Quotations/SGN <quotations@sgn.co.uk>

GCC have requested the following information:

Option 1

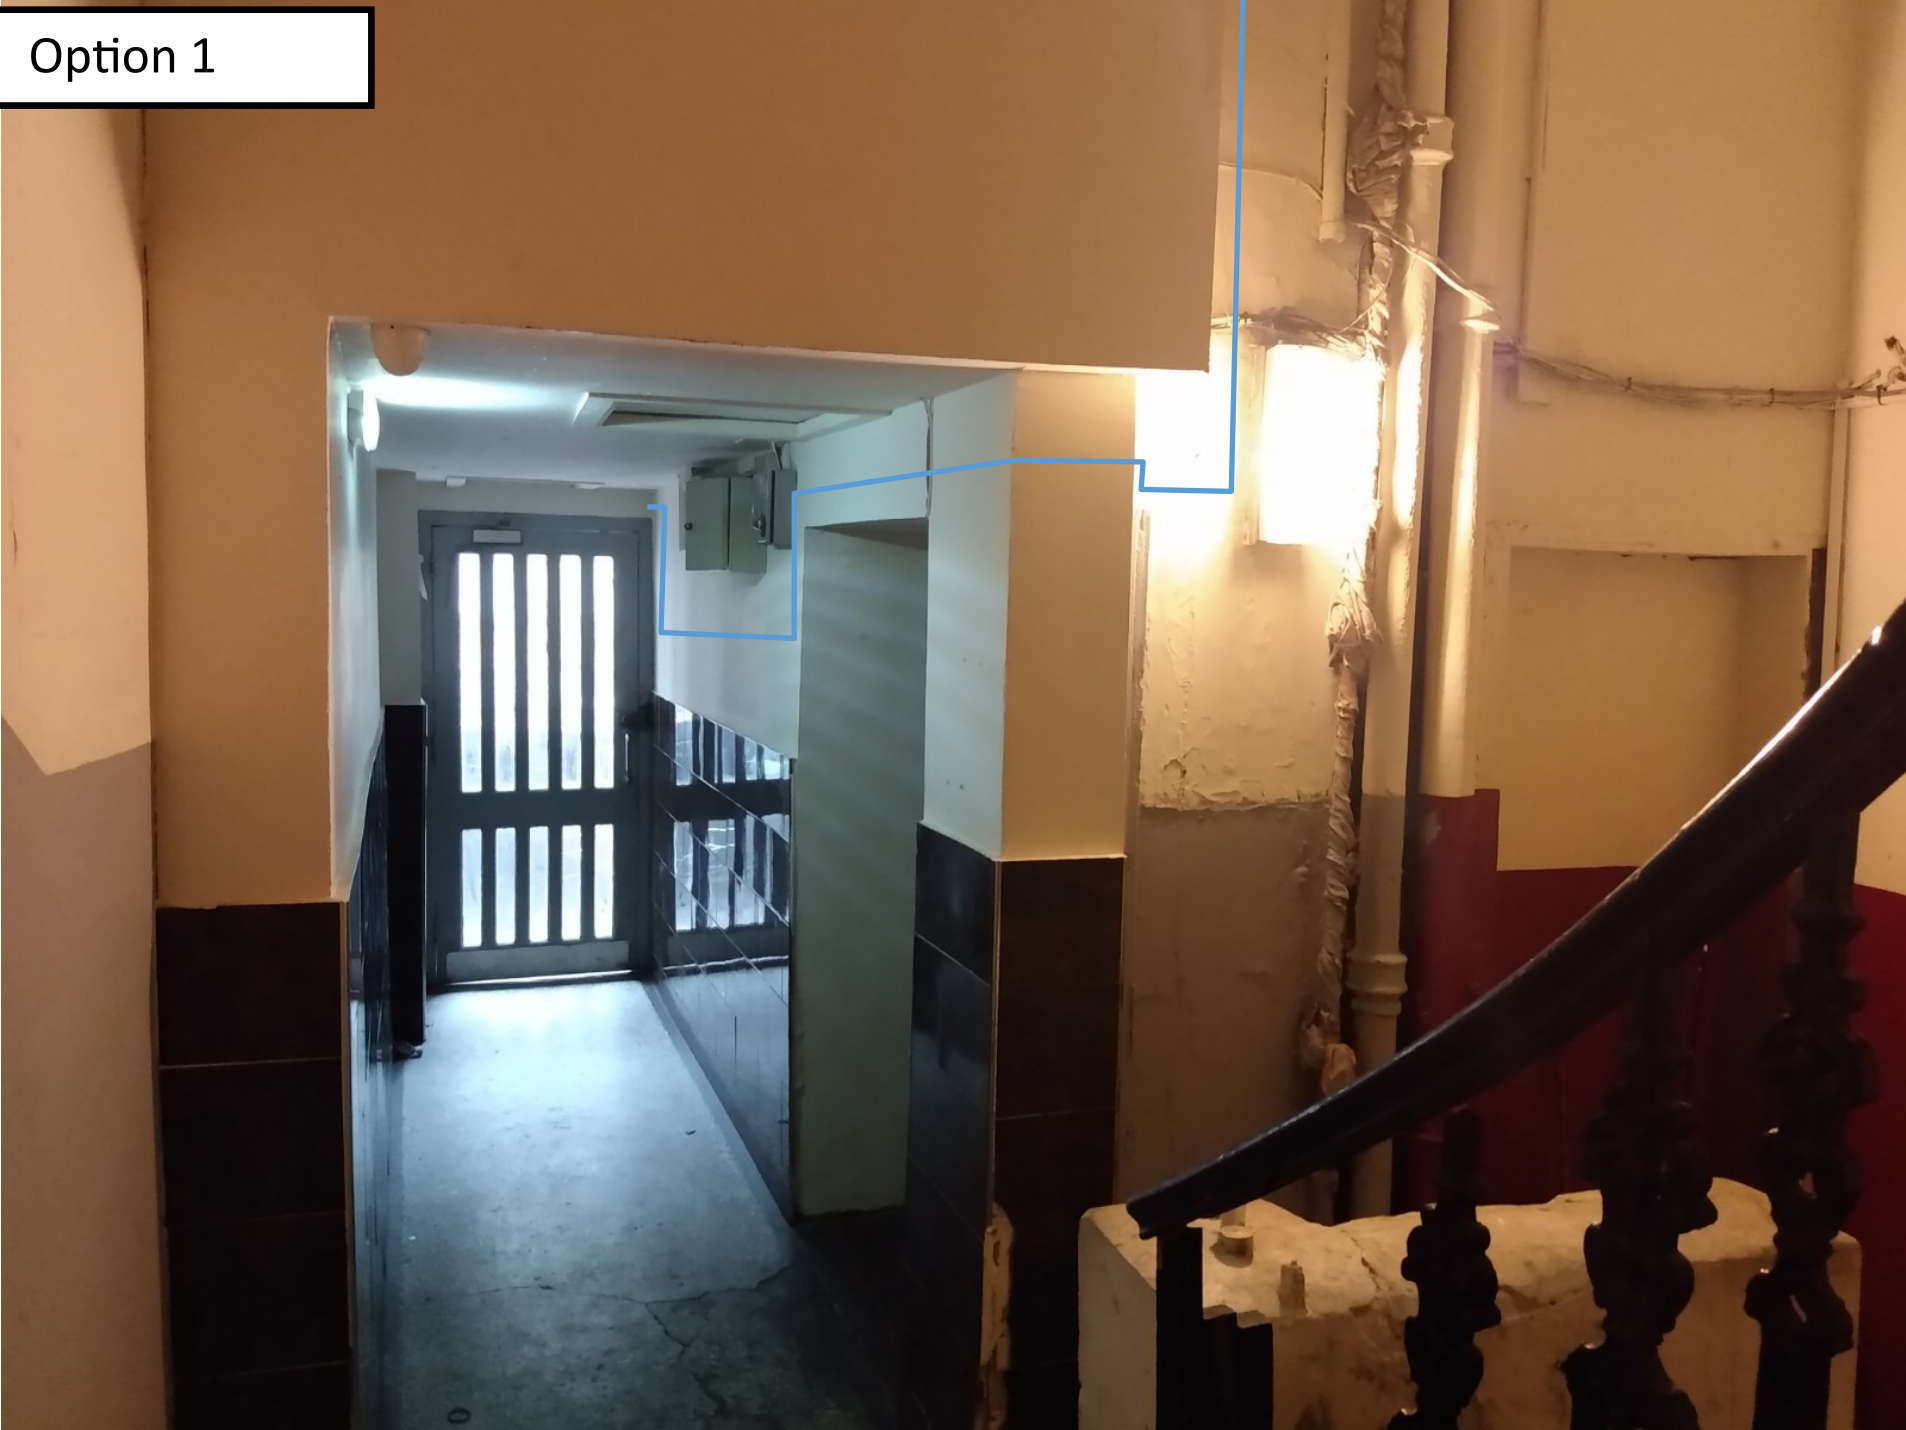
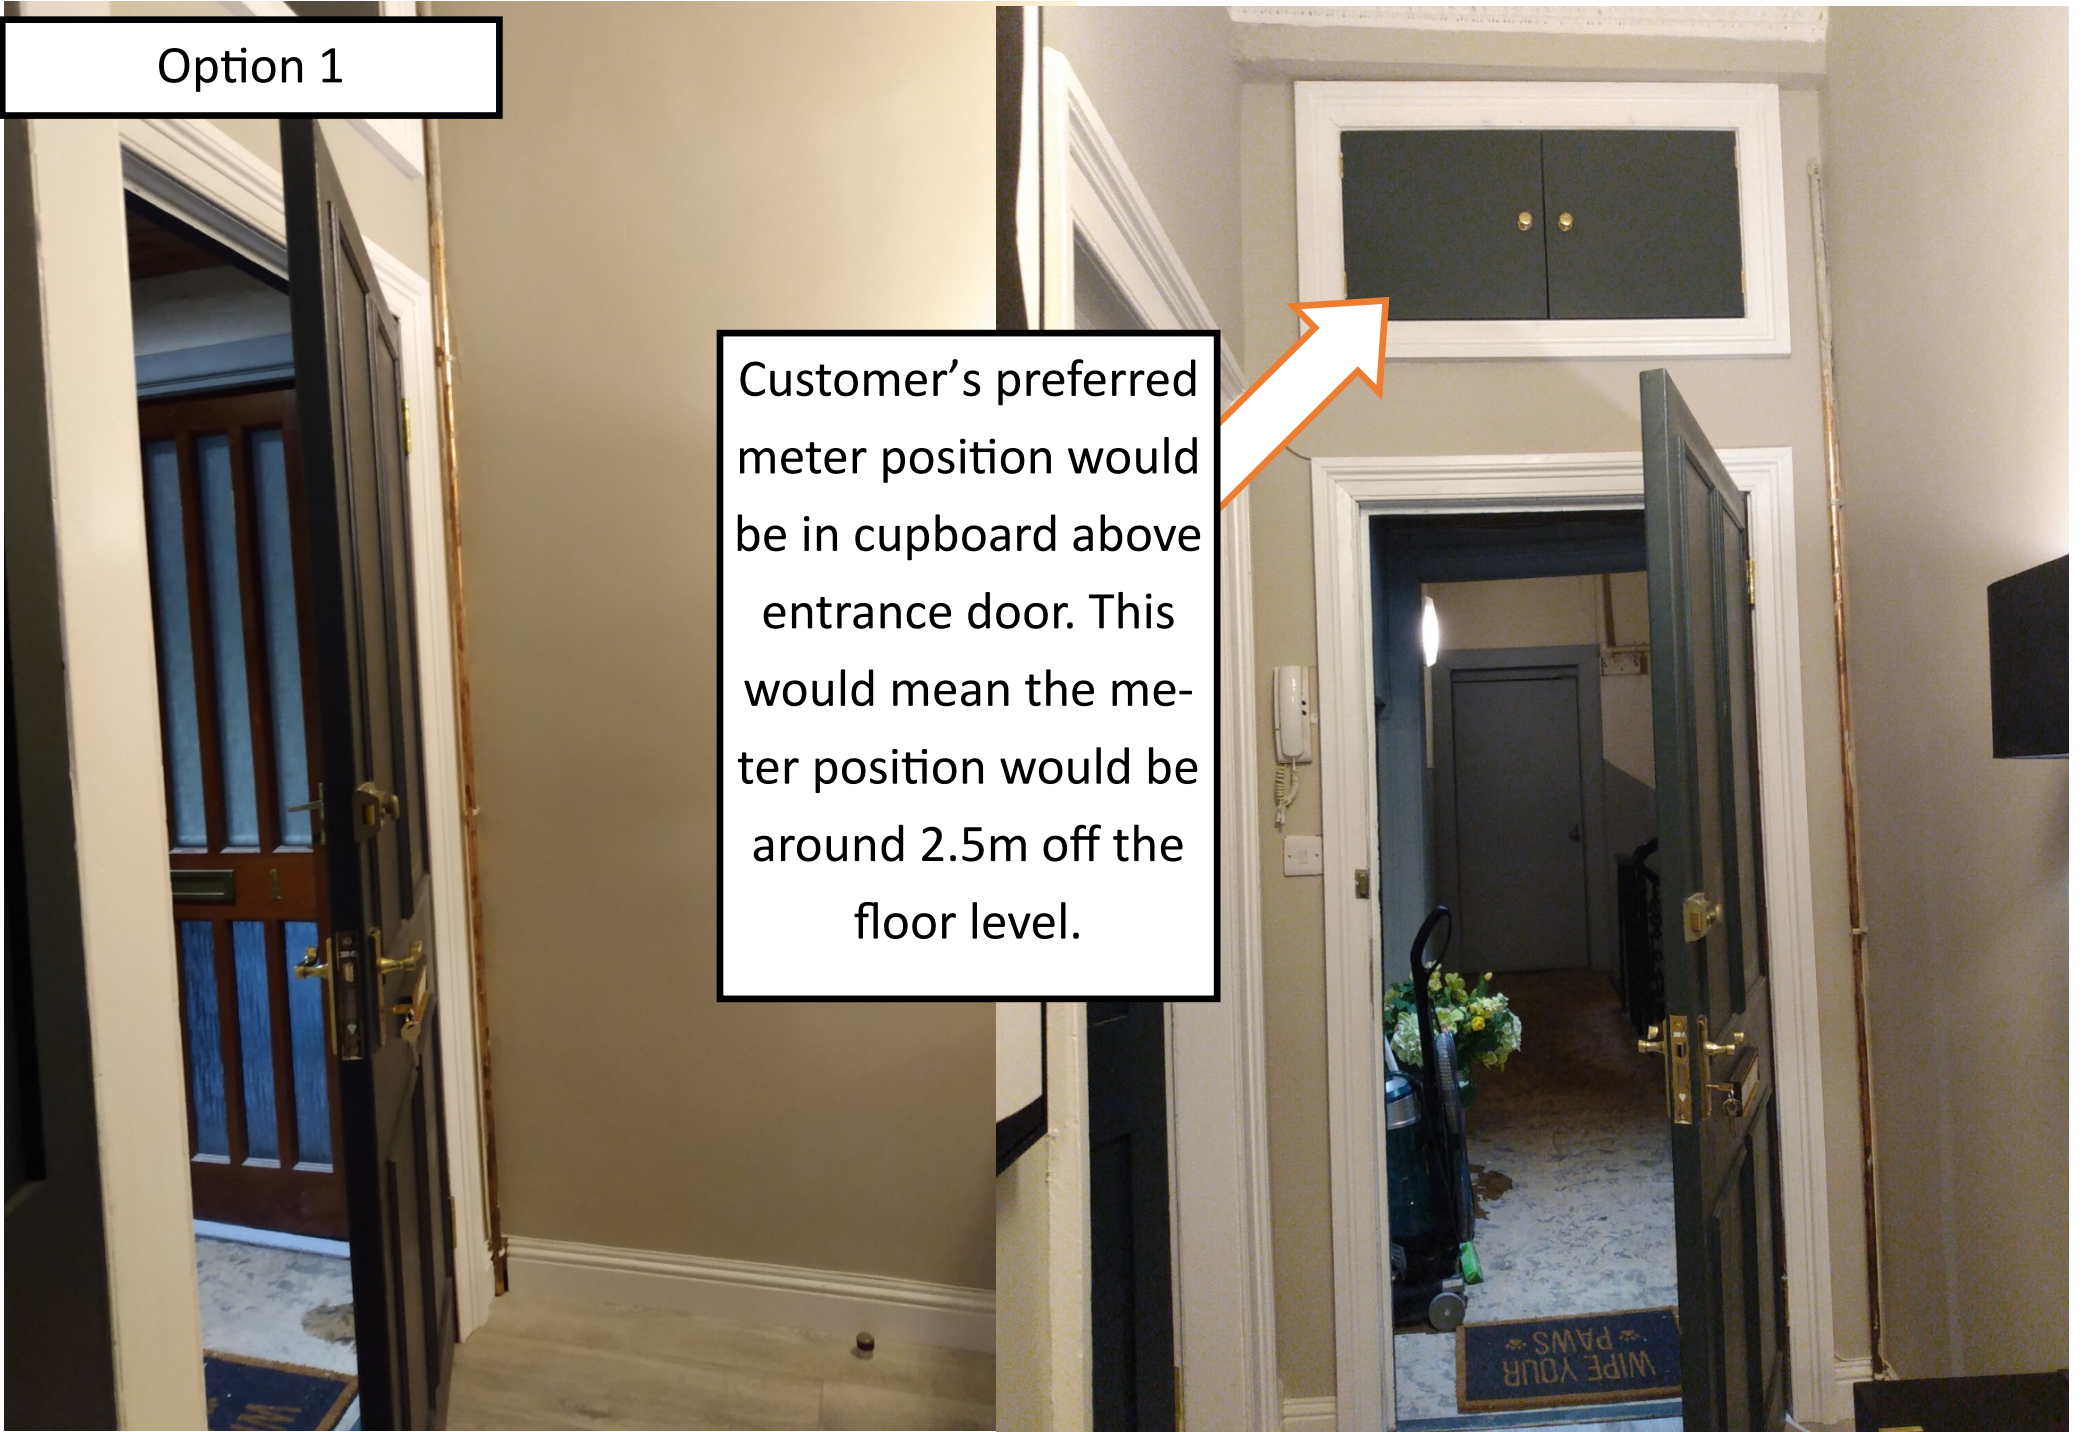
- **Diameter** of the pipe? – **63mm PE in footpath 1" steel above ground**
- What the pipe is made of? - **Plastic in the footpath Steel above ground**
- A diagram of the pipe to be installed as low as possible and to run up the lower frame of the ceiling within the close – **See attached pictures**
